State of Washington  
DEPARTMENT OF FISH AND WILDLIFE

**SUBJECT: WDFW COMMENTS ON JENTGES CONDITIONAL USE PERMIT (CU-26-00001)**

Thank you for the opportunity to comment on the conditional use permit for the Jentges small scale agricultural event facility proposed at 730 Alford Road, parcel numbers 474234 and 414234. The Washington Department of Fish and Wildlife (WDFW) has reviewed the application materials available on file, and we have specialized knowledge of the wildlife and critical areas surrounding the project area. As an agency of expertise, we offer the following comments to be considered as part of this review and determination process.

Critical Areas

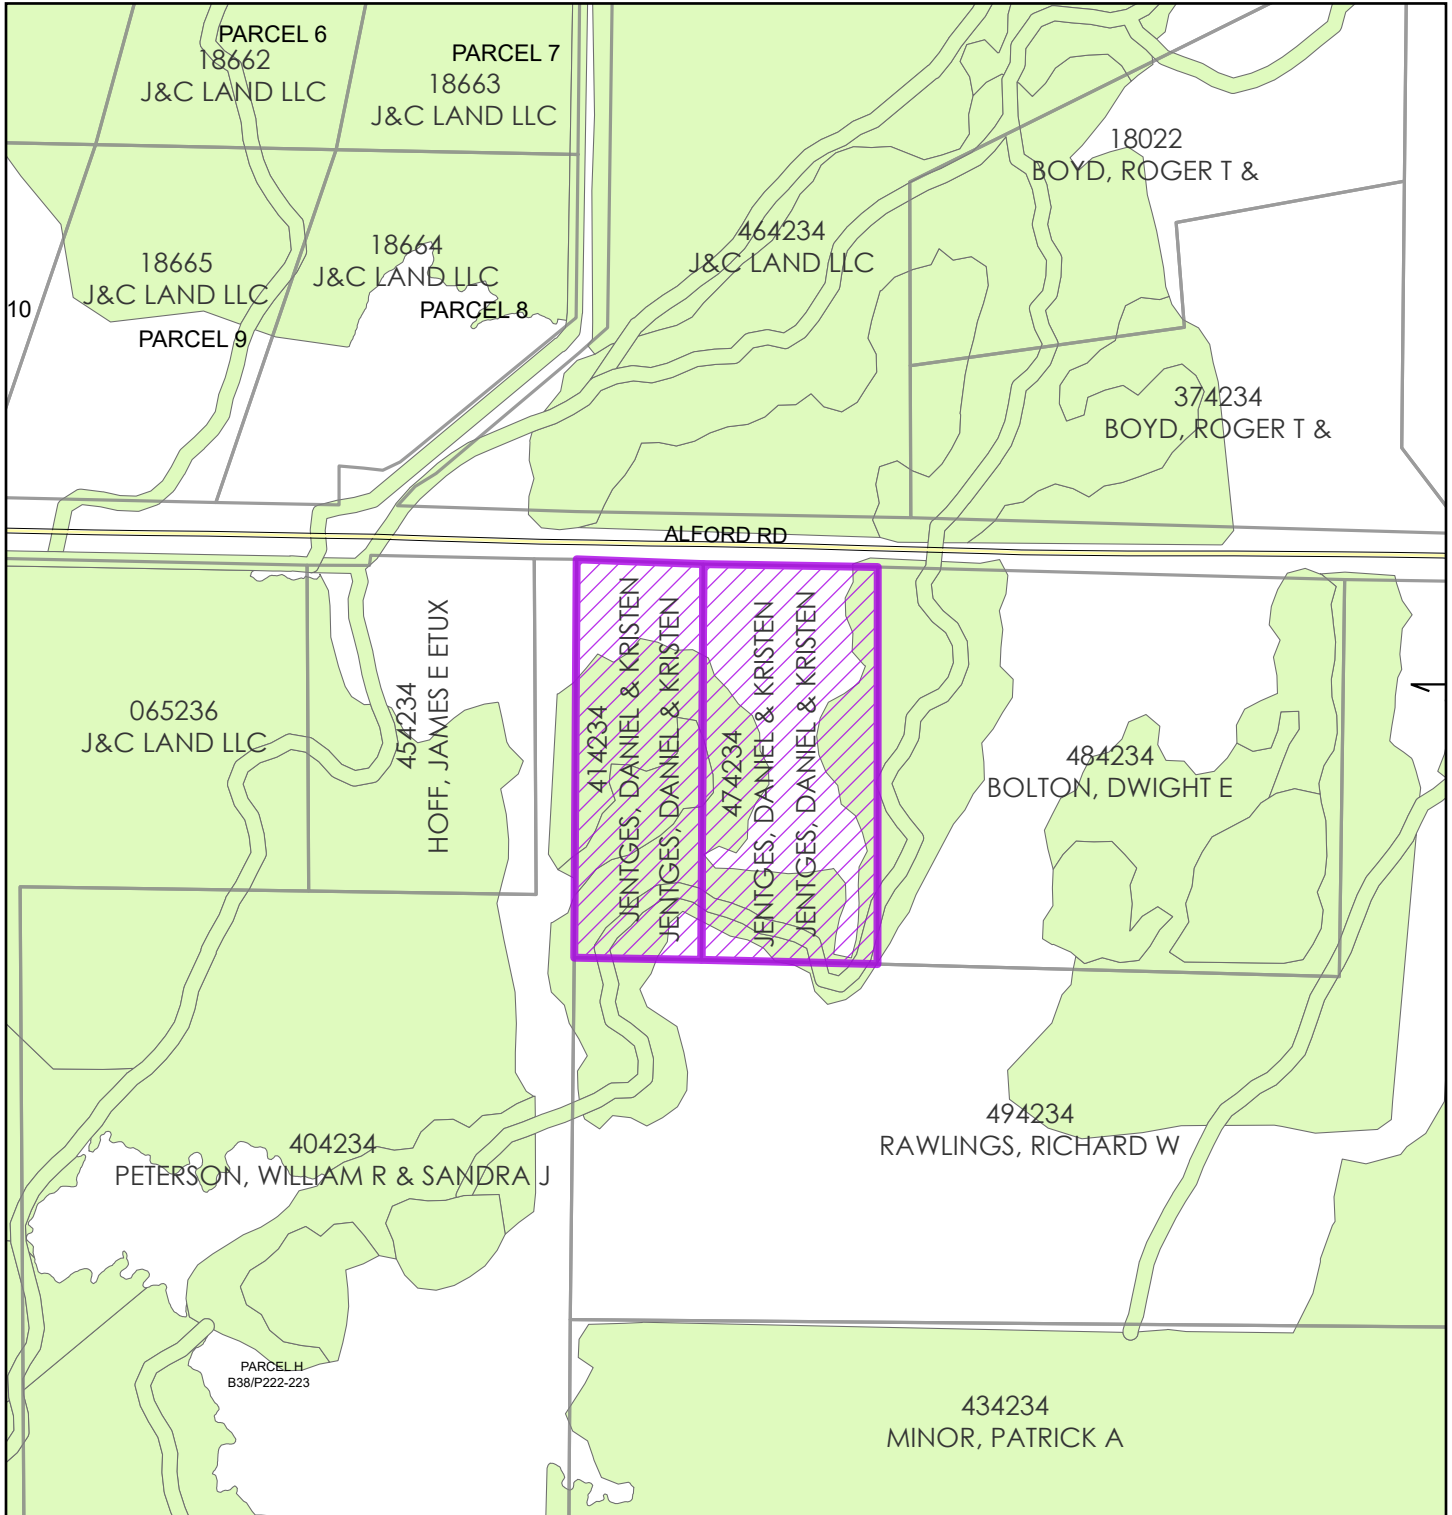
While we appreciate the critical areas map that was provided with the online materials, there does not seem to be a detailed critical areas report associated with this application to evaluate potential impacts to critical areas. Mercer Creek is a fish bearing stream and a distributary stream of Wilson Creek on the Wilson-Naneum Alluvial Fan. Native fish and freshwater mussels are present throughout Mercer Creek. The site plans provided with the application accurately show the main channel of Mercer Creek as "Stream", but they do not identify the two nearby high flow or flood relief channels that also convey flood waters (see Figure 1).

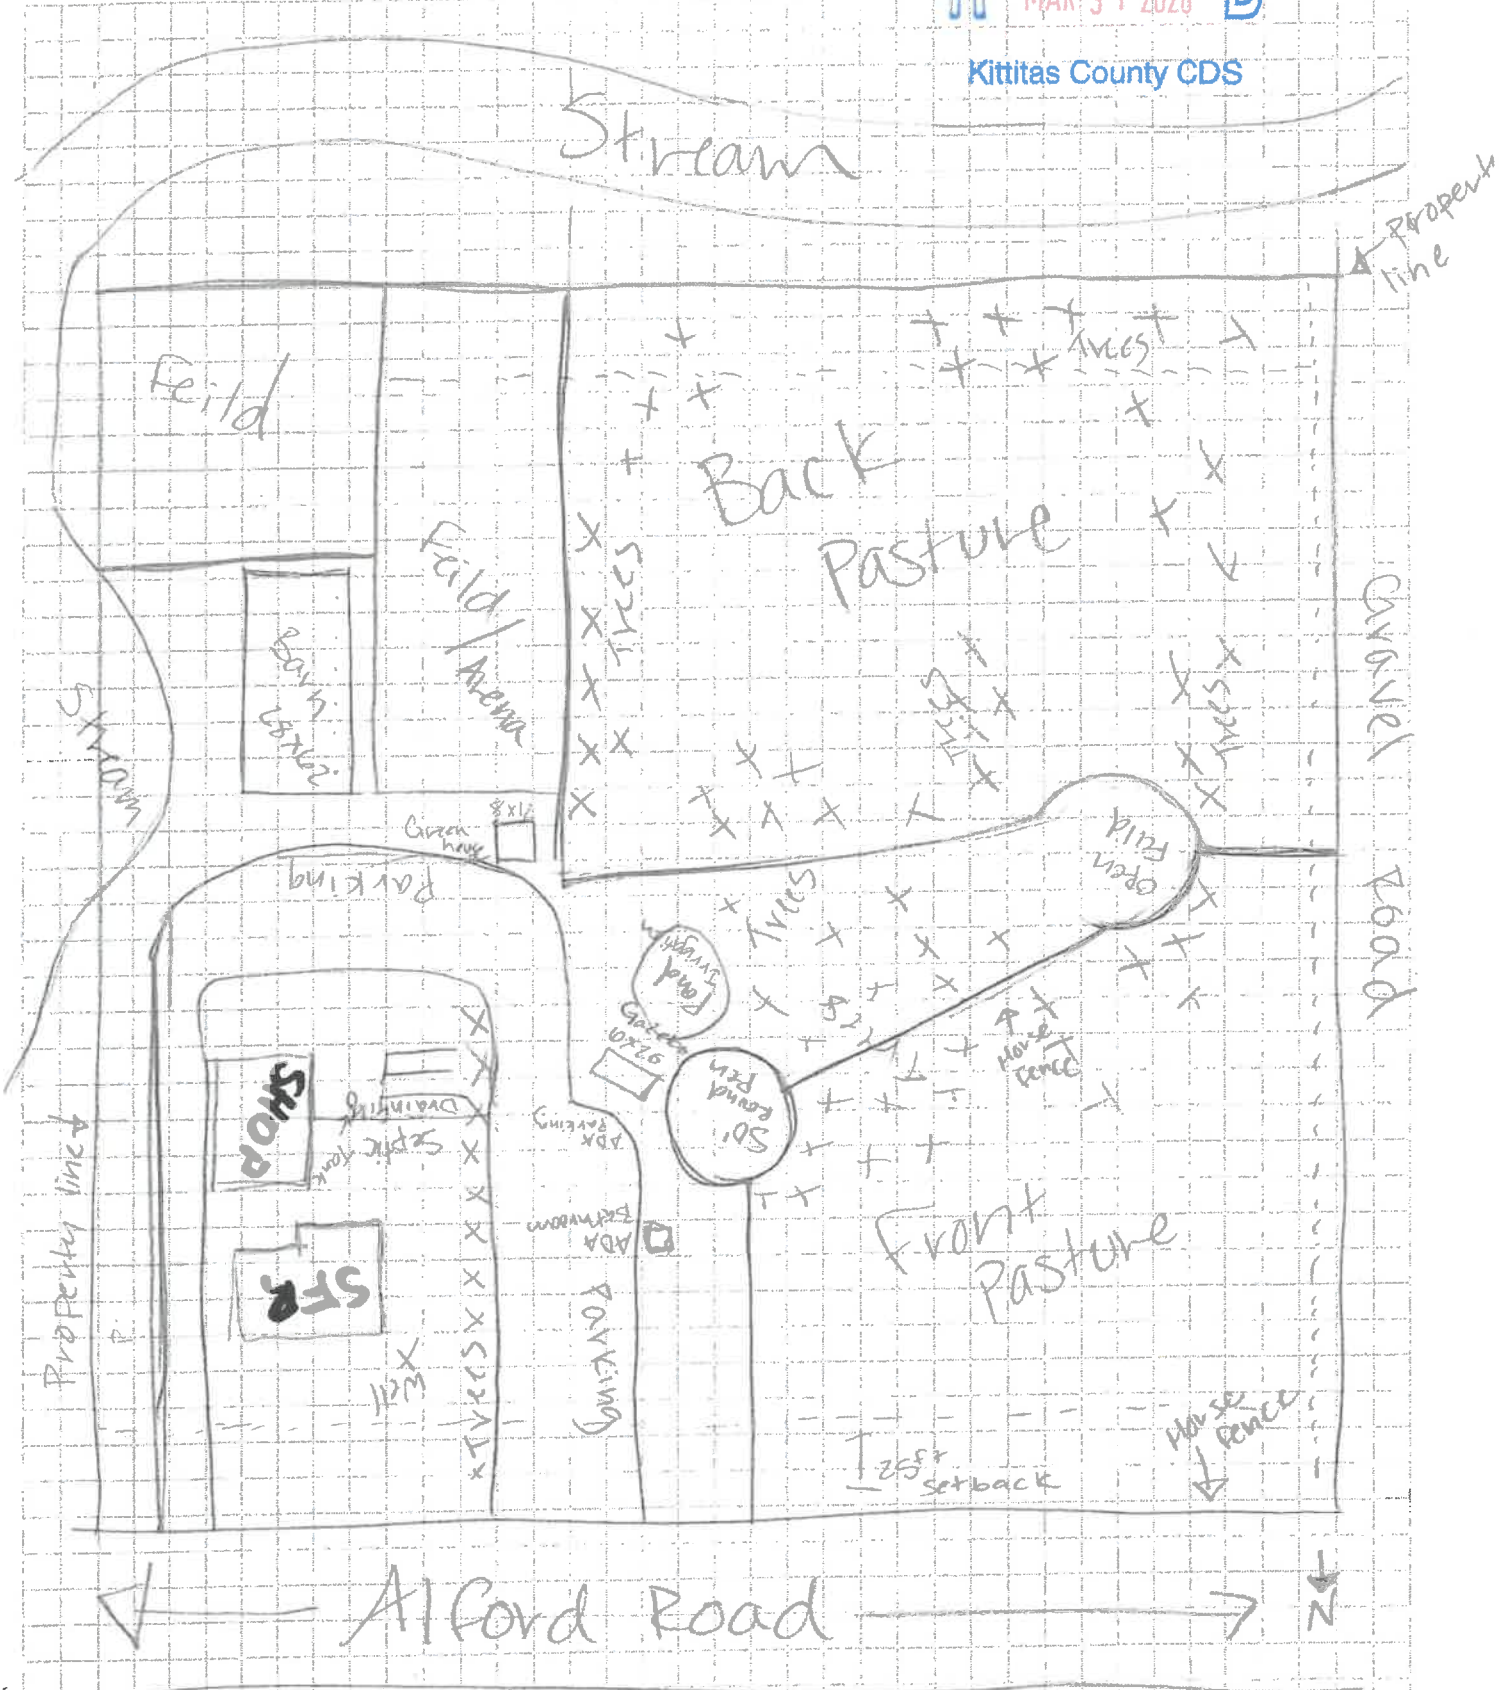
The application materials reference removal of underbrush to increase usable land, but few details exist as to where this will occur relative to the Riparian Management Zone associated with Mercer Creek in the County's Critical Areas Ordinance (KCC 17A.04.030). We understand that some structures already exist on site and that some new uses are proposed. What is not clear is how the critical areas have been identified and how they will be protected with approval of this conditional use permit.
